Babergh District Council submission to procedural deadline 1

This is the submission of Babergh District Council to deadline 1 of the examination for the North Falls Offshore Wind Farm project (EN010119). It consists of Babergh District Councils' Local Impact Report, expanding on those issues identified in the relevant representations submission of Babergh District Council to the examination.

1. Babergh District Council Local Impact Report (LIR):

OS reference:	608405 E 228479 N
AOD (Above Ordnance Datum):	34.3 m
Direction of view:	330°
Distance to proposed substation :	0.36 km

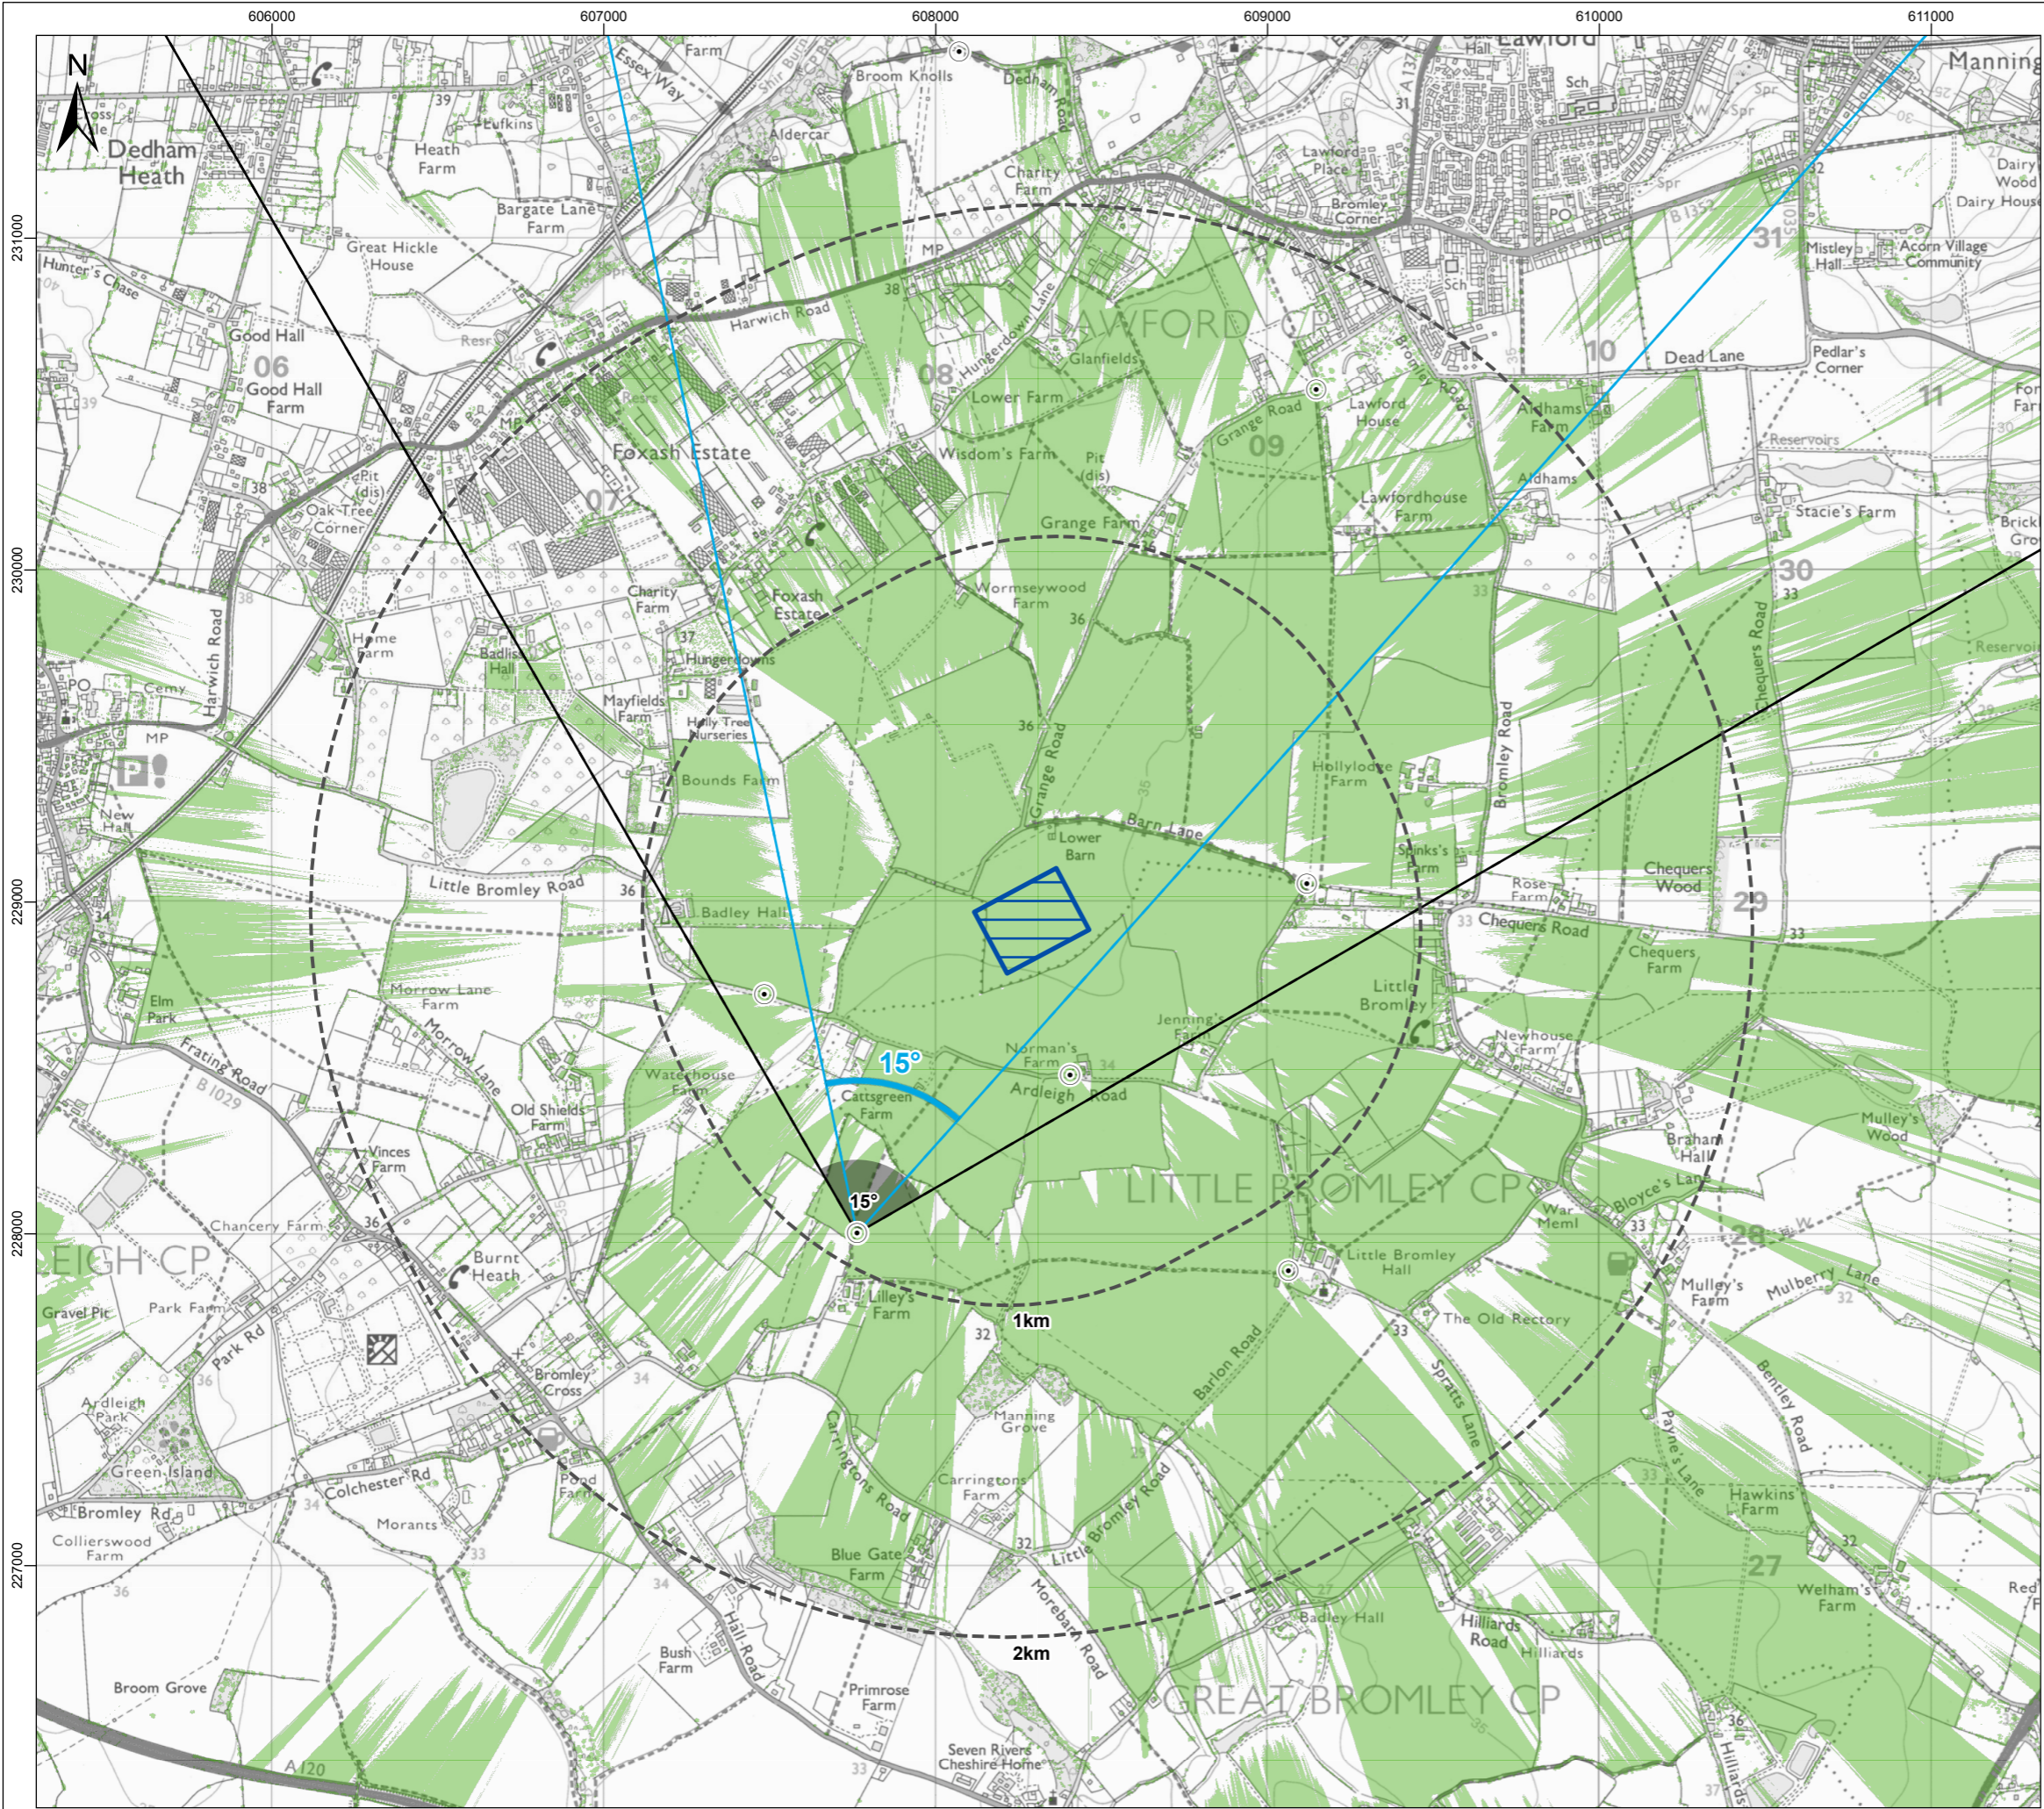
- 1.11 There are concerns that the cumulative effects of North Falls with the proposed Five Estuaries onshore substation, the East Anglian Connection Node (EACN), and the pylons that are proposed to connect to it from the Norwich to Tilbury (N2T) scheme would have a residual adverse cumulative effect on both visual receptors, the National Landscape or its setting.

- 1.12 The N2T pylons do not appear to be identified in the cumulative LVIA visualisations, and therefore it is assumed they haven't formed part of the LVIA cumulative impact assessment itself. The pylons will form part of the DCO for the Norwich to Tilbury project, along with the EACN so their cumulative impact needs to be considered.

# **Onshore Substation Zone of Theoretical Visibility and Viewpoint Locations with Dedham Vale National Landscape**

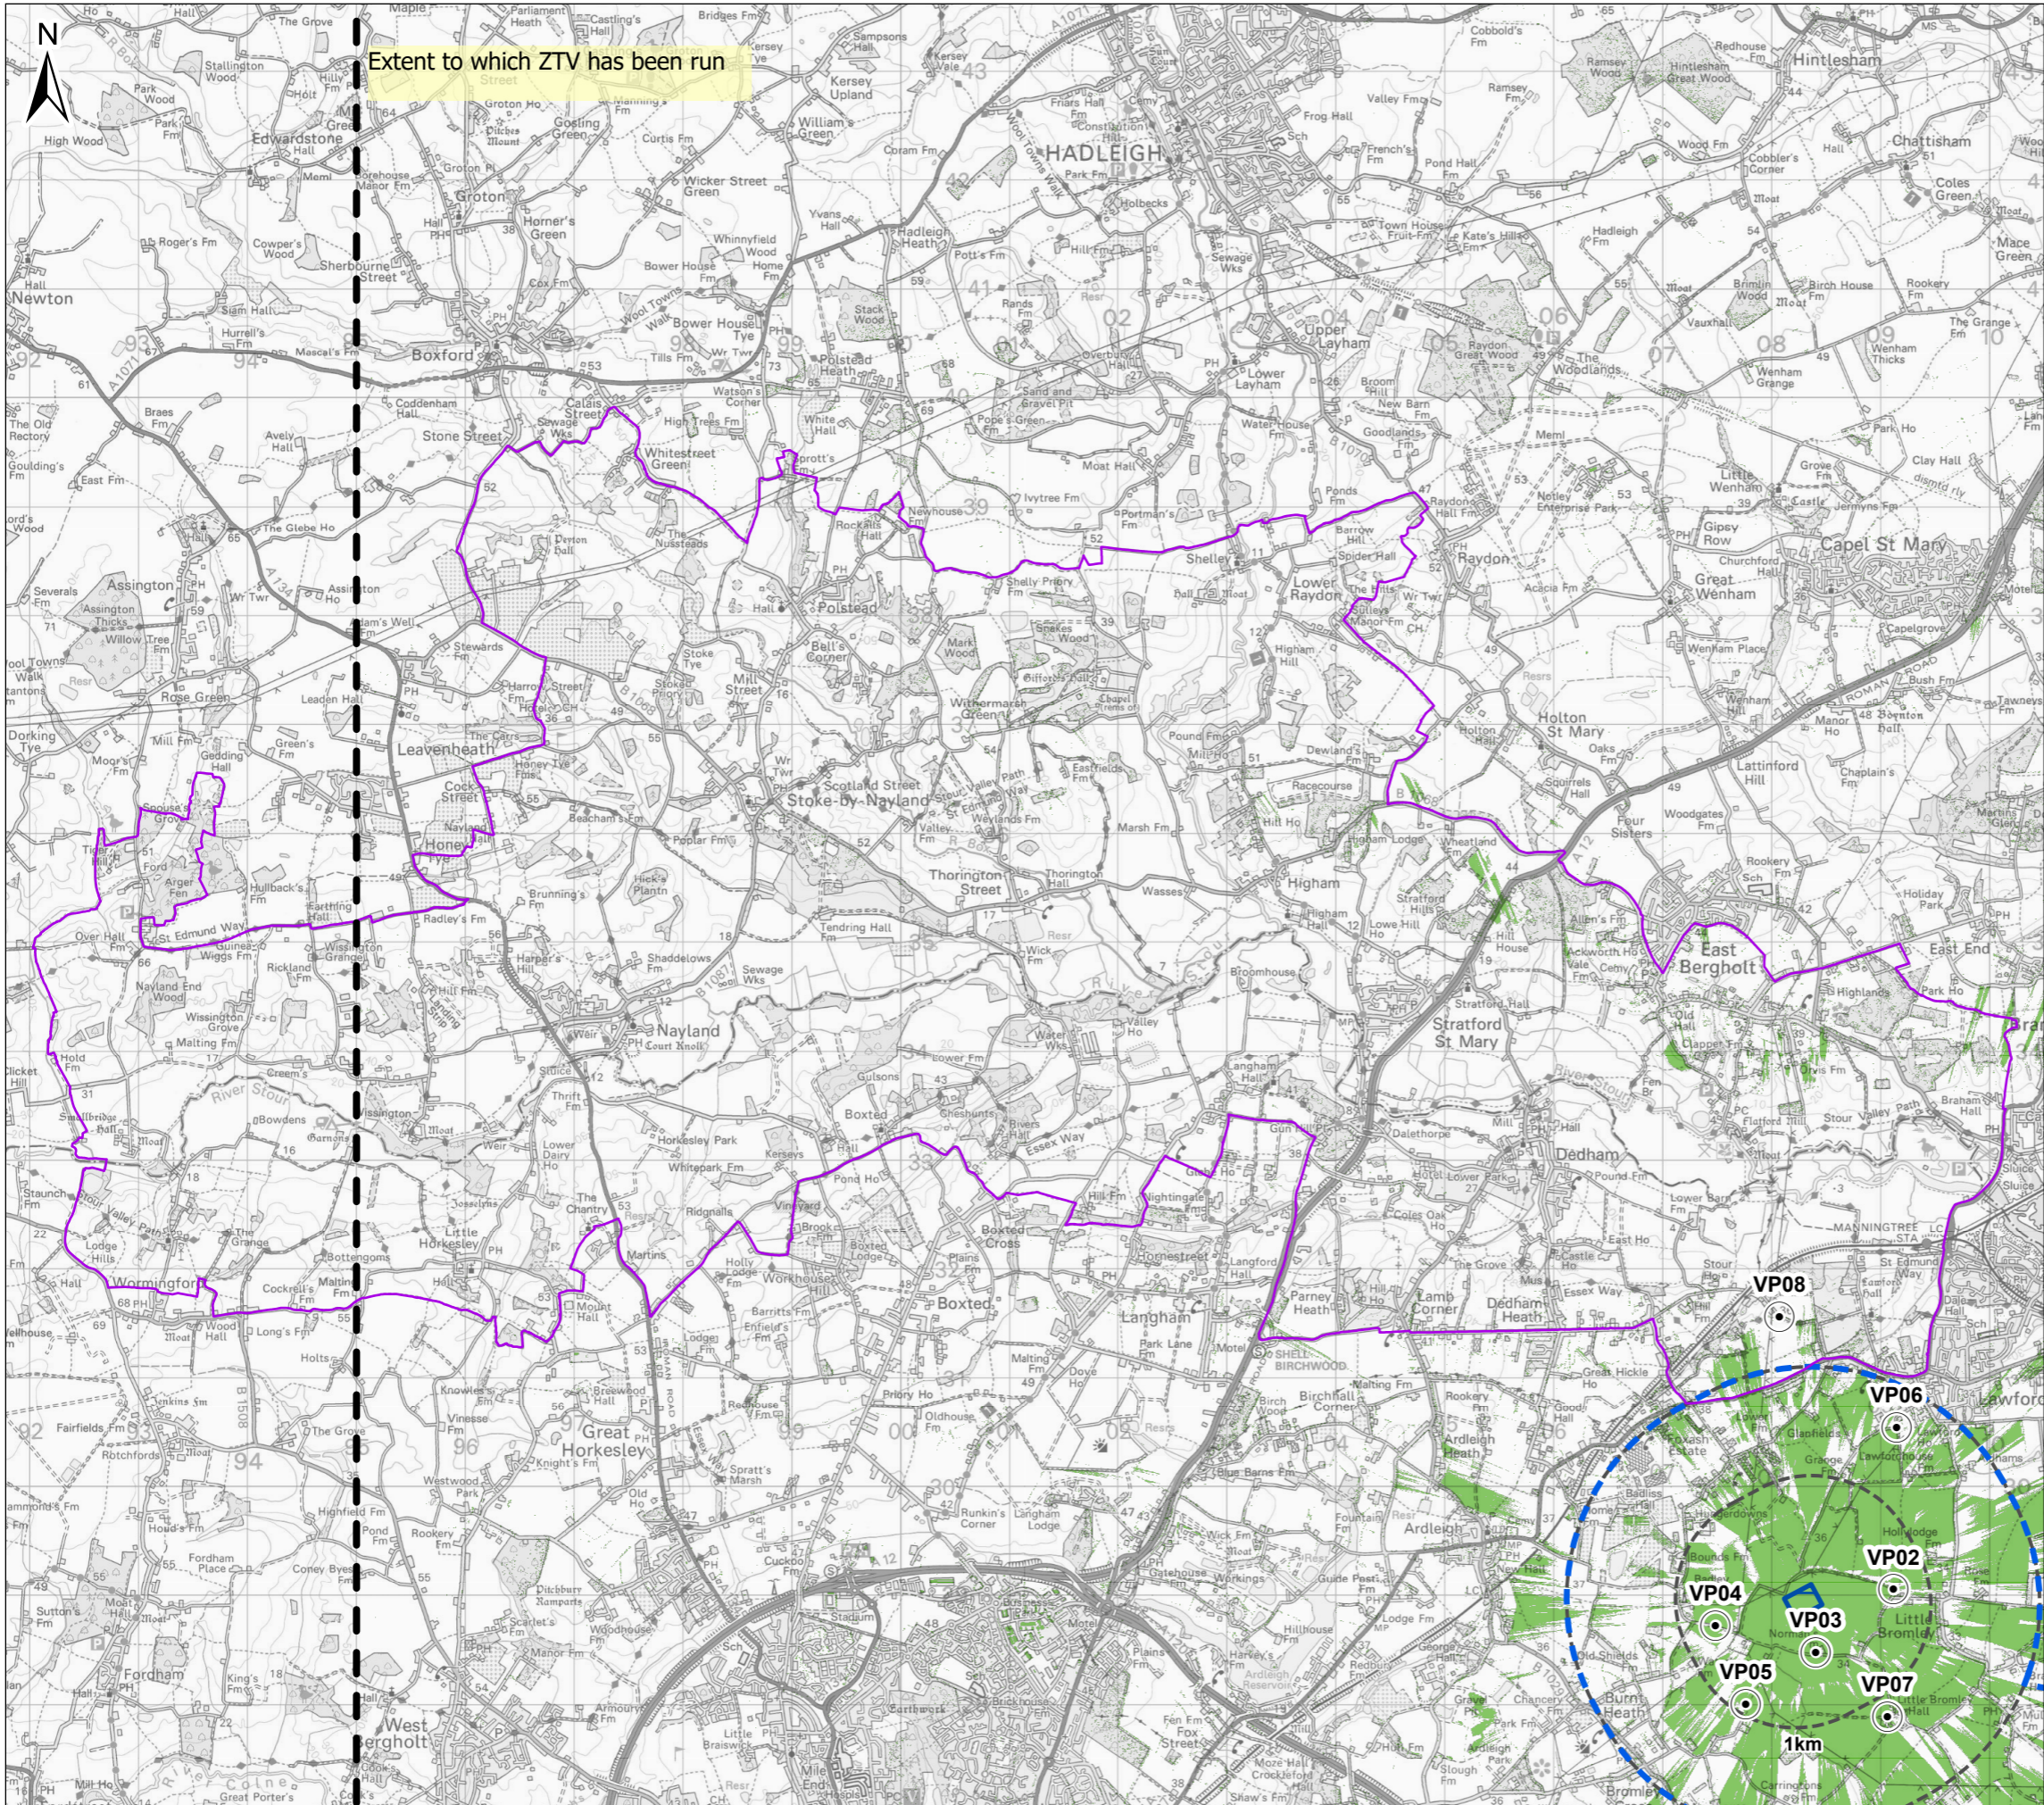
- 1.7 Babergh District Council are concerned that there is the potential for residual visual impacts both during construction and during operation from the Onshore Substation on the National Landscape or its setting, due to its scale.

- 1.8 This is of particular concern given that there is now a strengthened duty to 'seek to further' the statutory purpose of National Landscapes. It is considered that the Onshore Substation could undermine that statutory purpose and insufficient evidence has been provided to demonstrate that this duty has been complied with.

- 1.9 The Dedham Vale National Landscape is shown as being within 2km from the project substation operational boundary. There is an area of theoretical visibility from the southern edge of the National Landscape.

- 1.10 The proposed Onshore Substation represents a significant negative feature in the local landscape during construction and in the early years post-construction, with the maximum onshore substation equipment being up to 18m in height and the platform footprint occupying up to 58,800m2, the equivalent of approximately eight full scale football pitches.
